An  
Bord  
Pleanála

## Inspector's Report ABP-304632-19

<b>Strategic Housing Development</b>	366 no. residential units (184 no. houses, 182 no. apartments) creche and associated site works.
<b>Location</b>	Capdoo, Clane, Co. Kildare.
<b>Planning Authority</b>	Kildare County Council
<b>Applicant</b>	Ardstone Homes Limited
<b>Prescribed Bodies</b>	<ol style="list-style-type: none"><li>1. Irish Water (IW)</li><li>2. Transport Infrastructure Ireland (TII)</li></ol>
<b>Observer(s)</b>	61 number observations
<b>Date of Site Inspection</b>	5 <sup>th</sup> August 2019
<b>Inspector</b>	Fiona Fair

Drawing file: Architectural Drawings / PL72 Bins Mid Terrace Houses Own Door Apartments.pdf

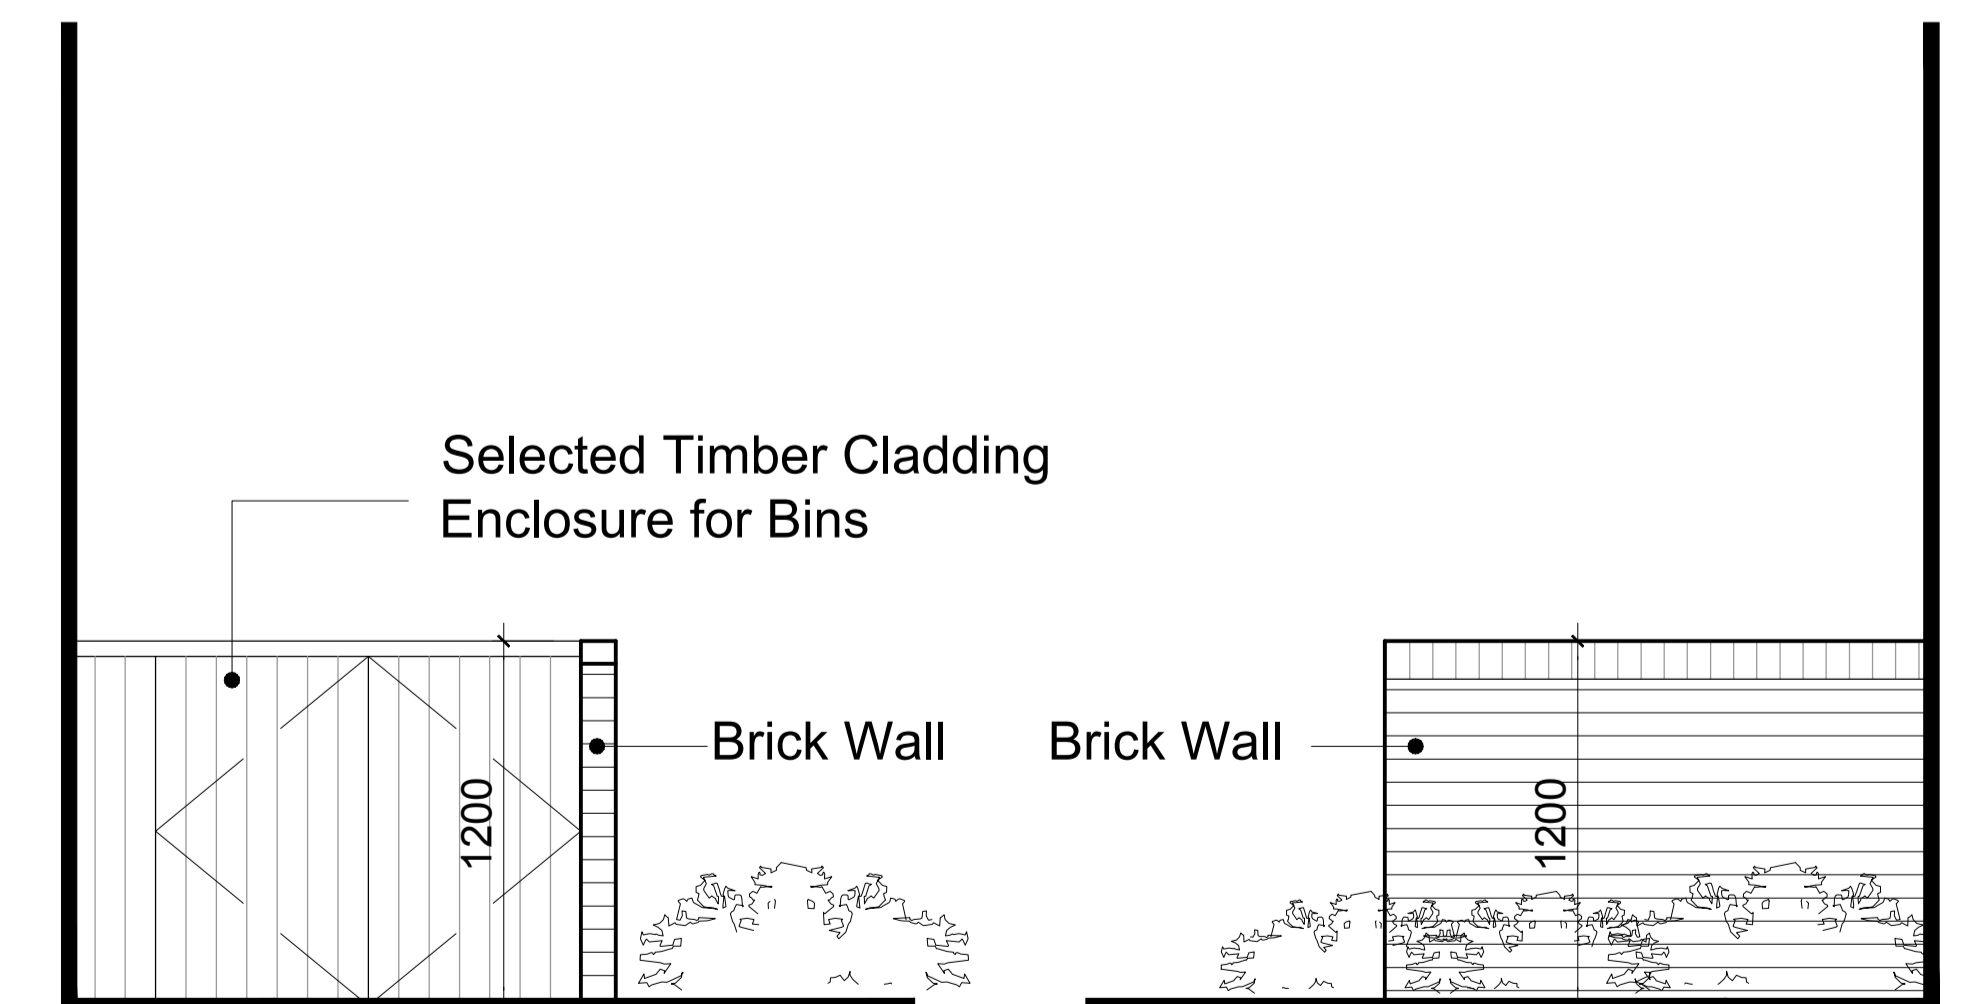
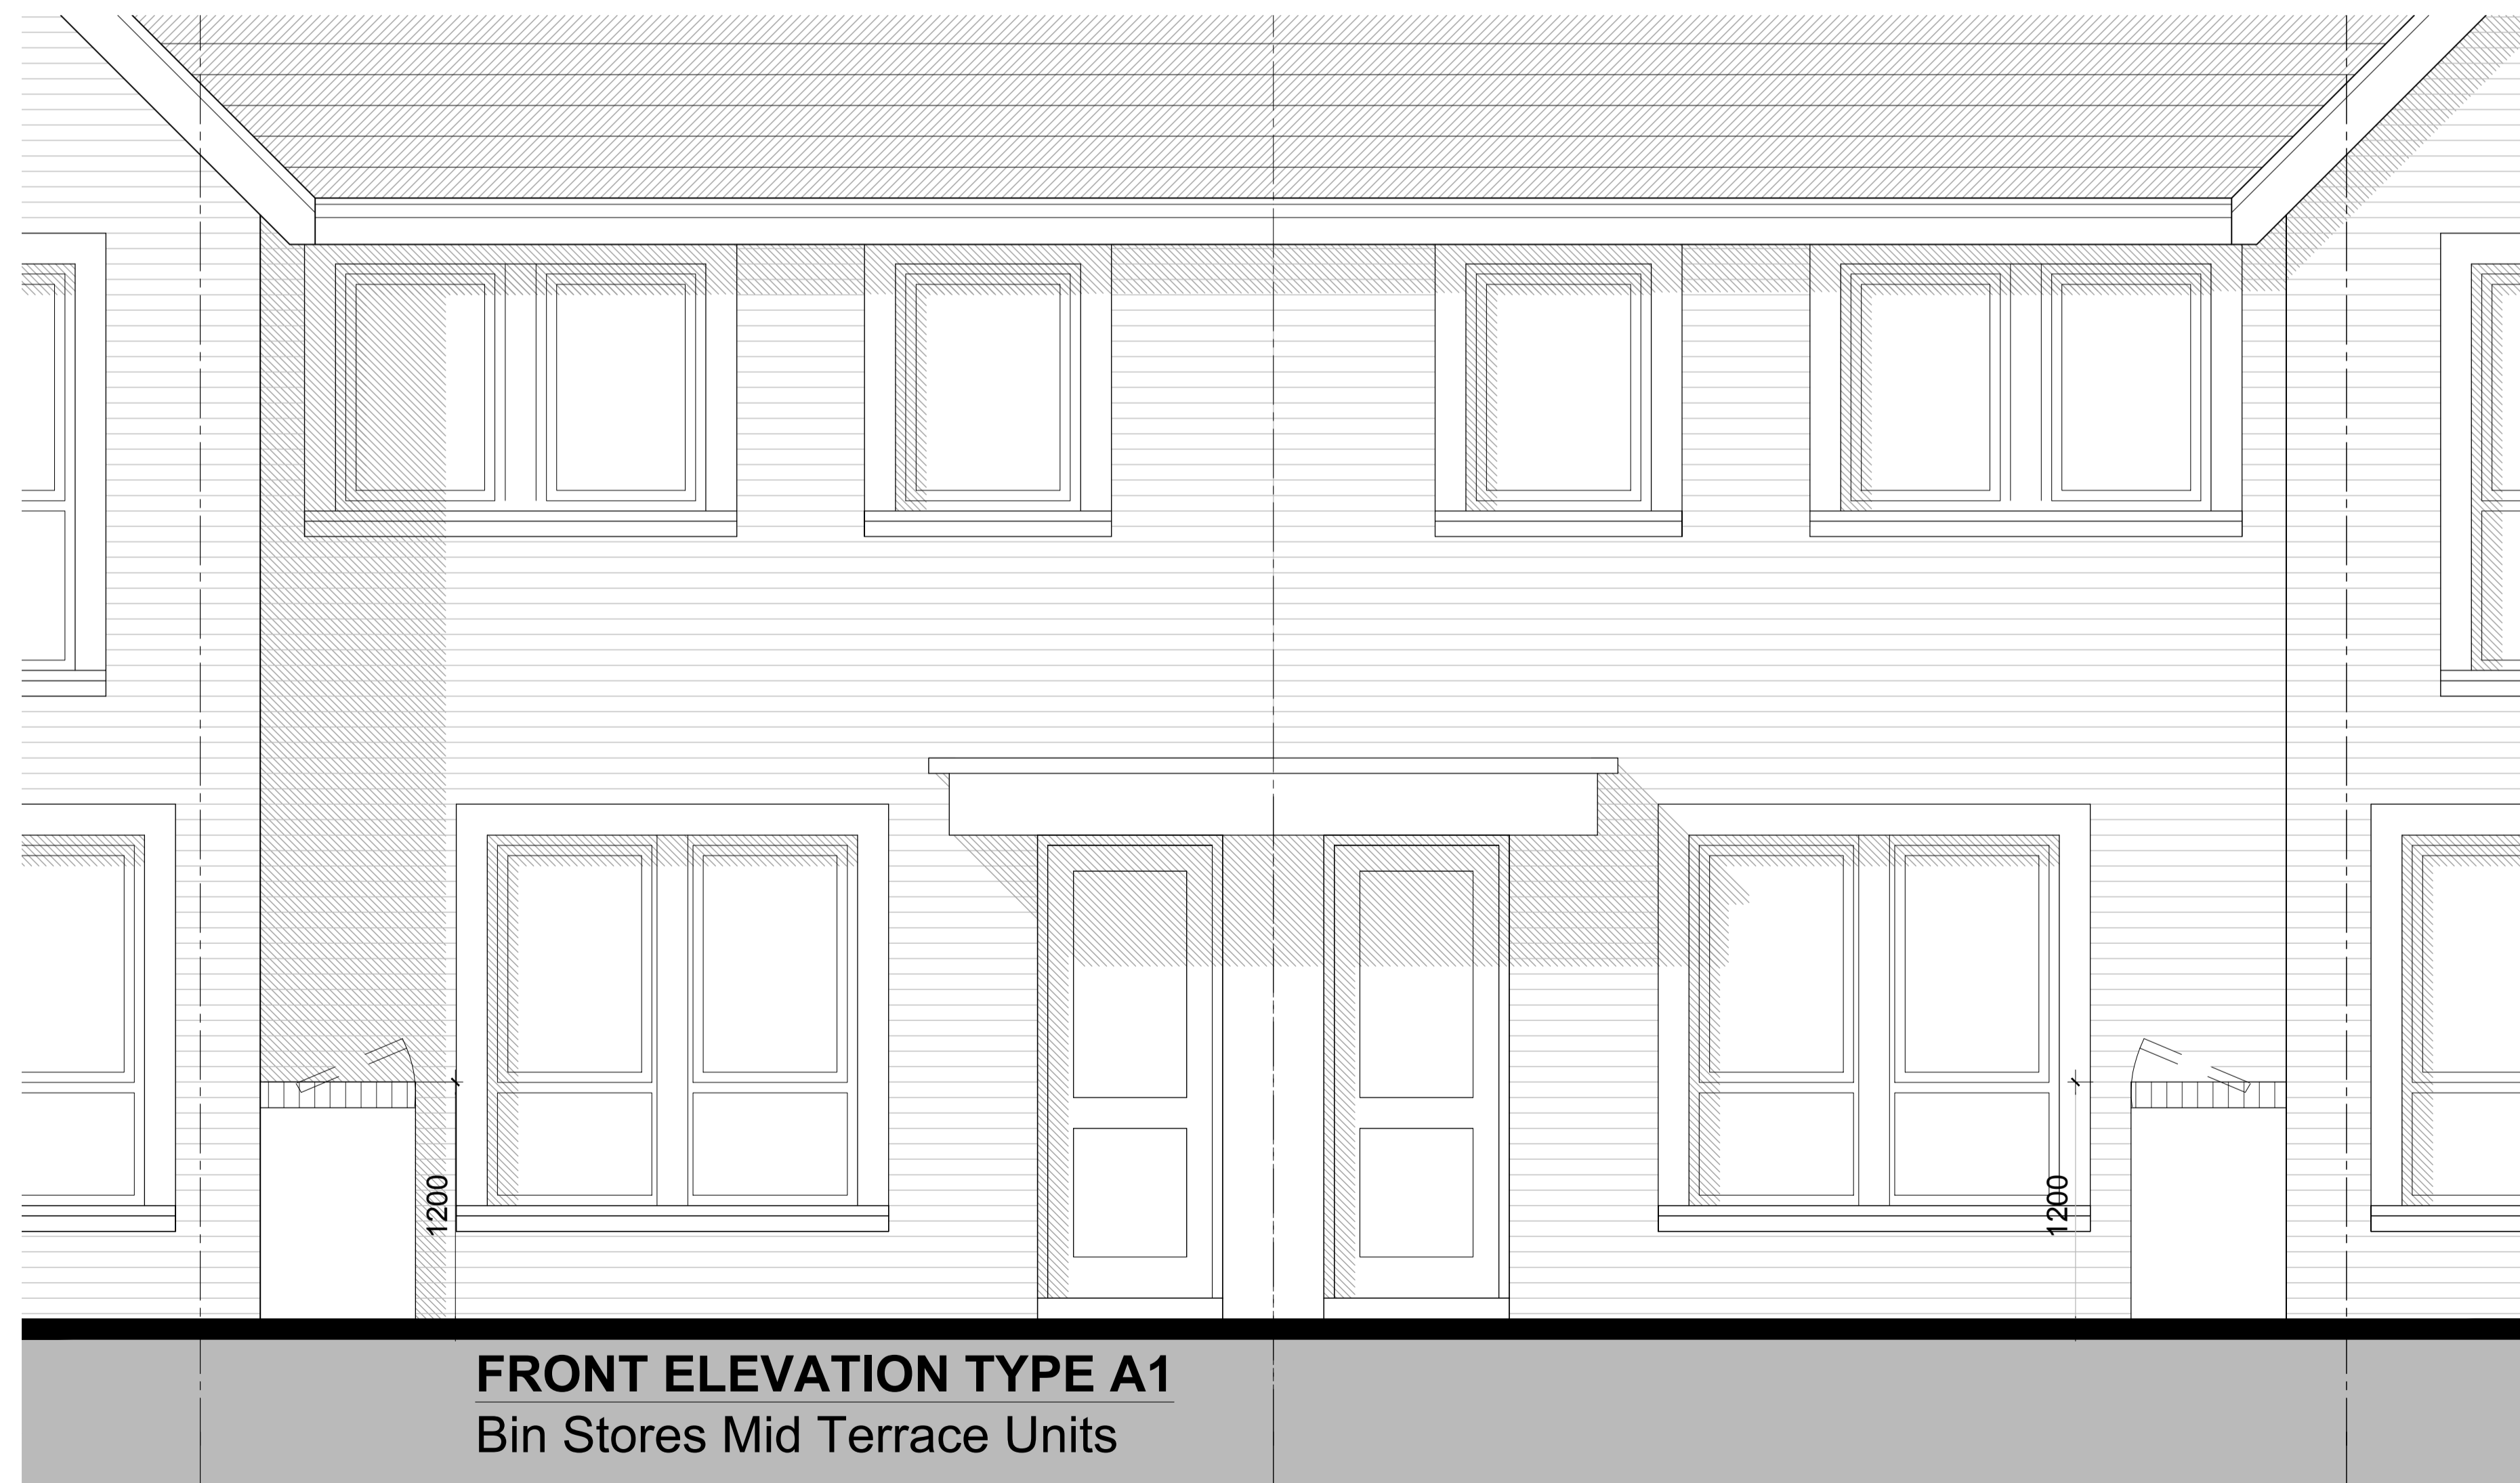
Response refers to MOLA Dwg. No. PL72 and PL73 for details of bin stores for apartments and terraced houses. The locations of bin stores are indicated on the Site Layout Plan Dwg. Nos. PL02, PL03 & PL03.
